Re: Sts. Peter & Paul Church School Addition Project # 1000400- 14EPC-40086

Subject: EPC Conditions incorporation narrative.

Orcutt Winslow Project no. 2014_003

To: Jack Cloud, Development Review Board Chair
From: Vicente M. Quevedo - Planner 
CC: Ashish Dandavate, Architect and Tim Scolaro, Architect – Orcutt / Winslow
Date: Monday June 1, 2015
Re: Project 1000400, 14EPC-40086 – Site Development Plan for Building Permit

SHEET NO.  
AS102

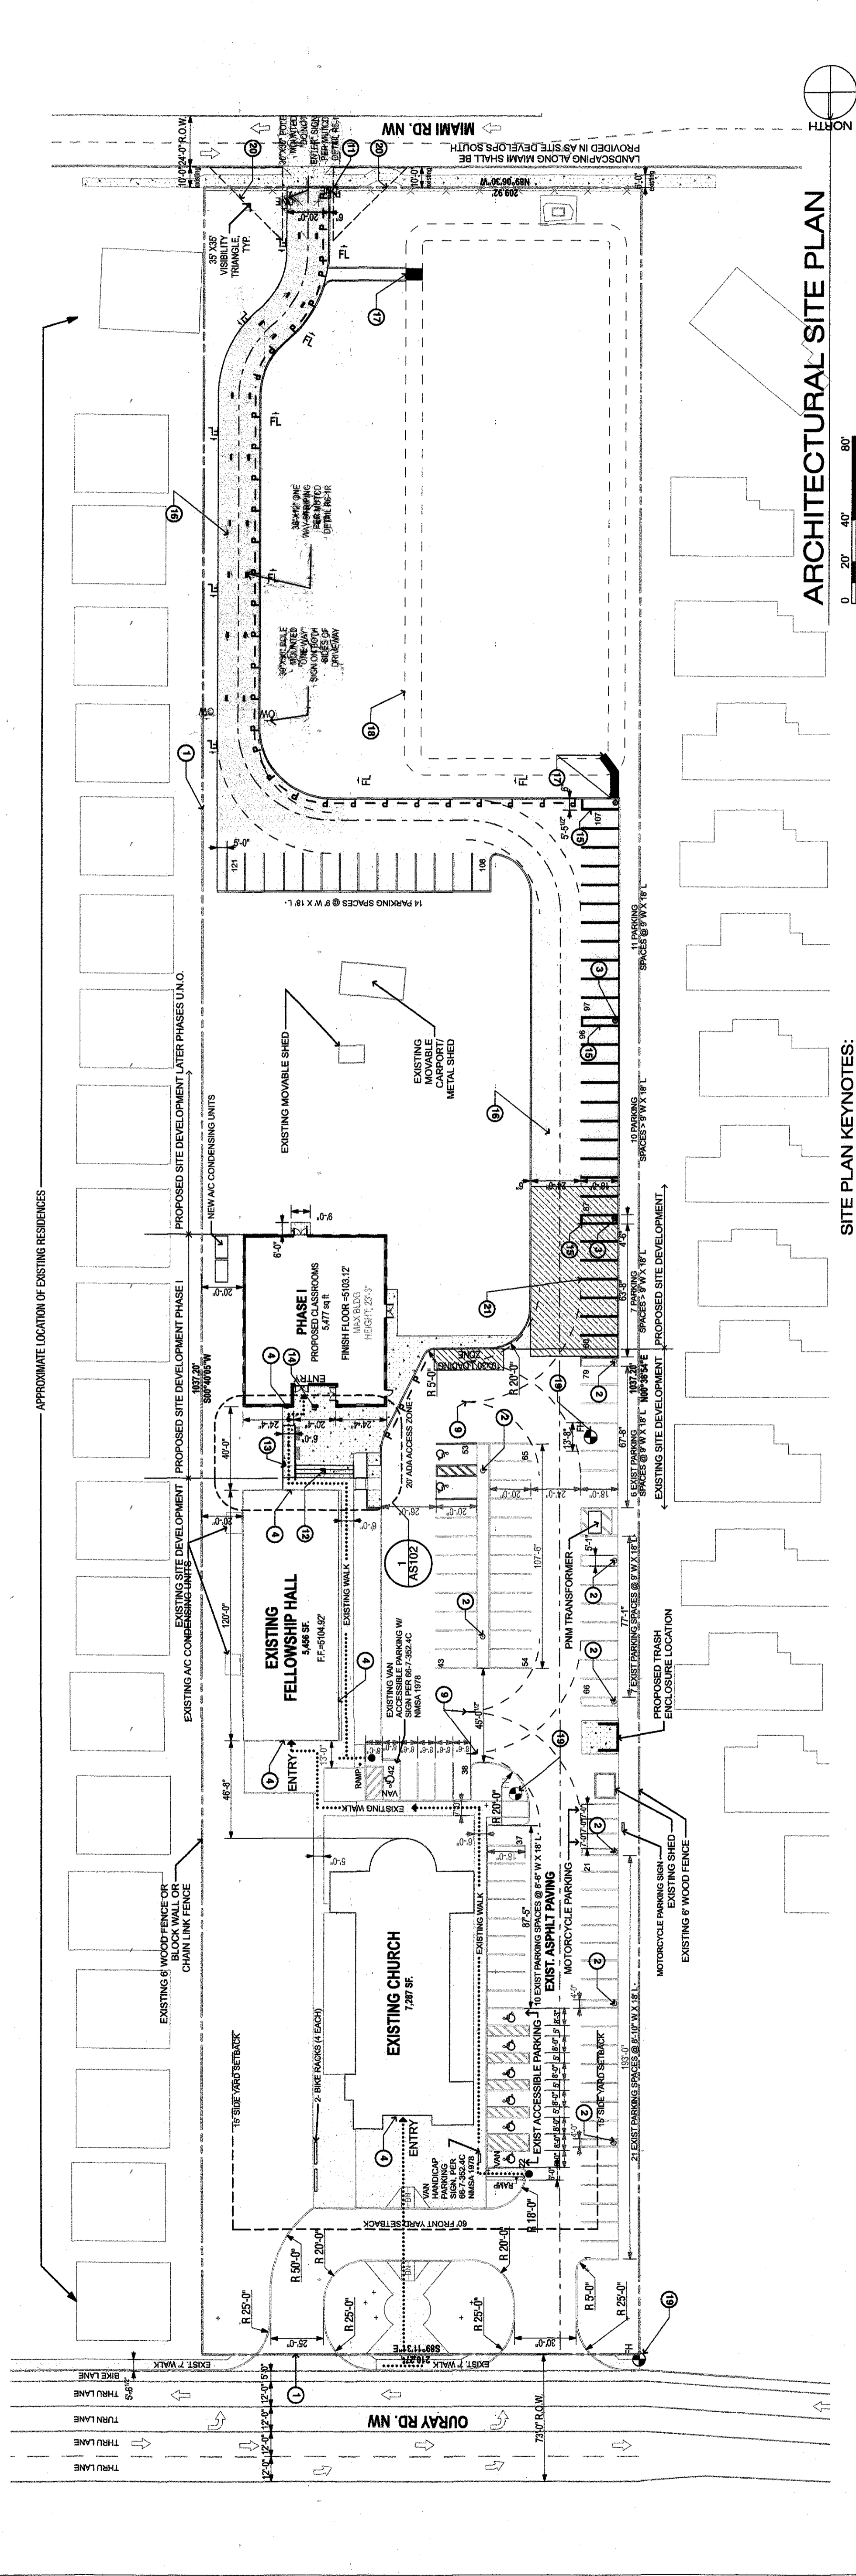
6. Additional seating shall be provided near the proposed Phase 1 school building and note added to the site plan keynotes on sheet AS102 denoting the added seating.

- A. Provide an ADA van accessible sign for the van accessible space and/or spaces. The ADA van accessible sign must have the required language per 66-7-352.4C NMSA 1978 "Violators Are Subject to a Fine and/or Towing."

- B. It is recommended to have a minimum of one handicapped space near the proposed/future buildings.
 - C. The required ADA access aisle shall have the words "NO PARKING" in capital letters, each of which shall be at least one foot high and at least two inches wide, placed at the rear of the parking space so as to be close to where an adjacent vehicle's rear tire would be placed. (66-1-4.1.B NMSA 1978)

- D. If the drive out onto Miami Road NW is a one-way exiting road, provide pavement directional signage and a posted "Do Not Enter" sign at the point of egress at Miami Road NW, and show the existing 16-foot drive-pad to remain undisturbed. Otherwise, this drive would have to be widened to 24 feet for two-way traffic.

- G. A five-foot keyway is required for dead-end parking aisles. This applies to both the south side of the new parking facility as part of Phase I and the far east side of the future parking spaces along the Phase III building.
- H. For the new asphalt parking lot surface, label the proposed pavement thickness and typical section.
- I. Provide additional information regarding Ouray Road access. Address traffic conflict concerns with Americare Court and Maiden Grass Road given that the easternmost drive is very close to both of these intersections. Queuing information should be provided.
- J. Developer is responsible for permanent improvements to the transportation facilities adjacent to the proposed development site plan, as required by the Development Review Board (DRB).

Condition 6: Revised Site plan shows 2' wide concrete steps for seating north of the proposed classroom building. These will create a courtyard with "amphitheatre" setup that the students and faculty can use for outdoor activities. In addition we have added two (2) 6' long benches to this courtyard for additional seating. See enlarged plan detail #1 on sheet AS-102.

Comment 7A: See detail for accessible parking on sheet AS-102.

Comment 7B: 2 Accessible spaces provided near proposed classroom building. ADA parking symbols added per our discussion.

Comment 7C: See detail for accessible parking on sheet AS-102.

Comment 7D: See revised note #7 on sheet AS-102.

Comment 7G: See dimensioned parking file layout on sheet AS-102.

Comment 7I: An asphalt-paved one-way driveway has been proposed in this phase of the project, see site plan AS-102. This driveway connects Ouray Road and Miami Road, which alleviates the congestion situation at the subject intersections. See additional sheet AS-104 with traffic pattern and drop off, queuing area on this campus.
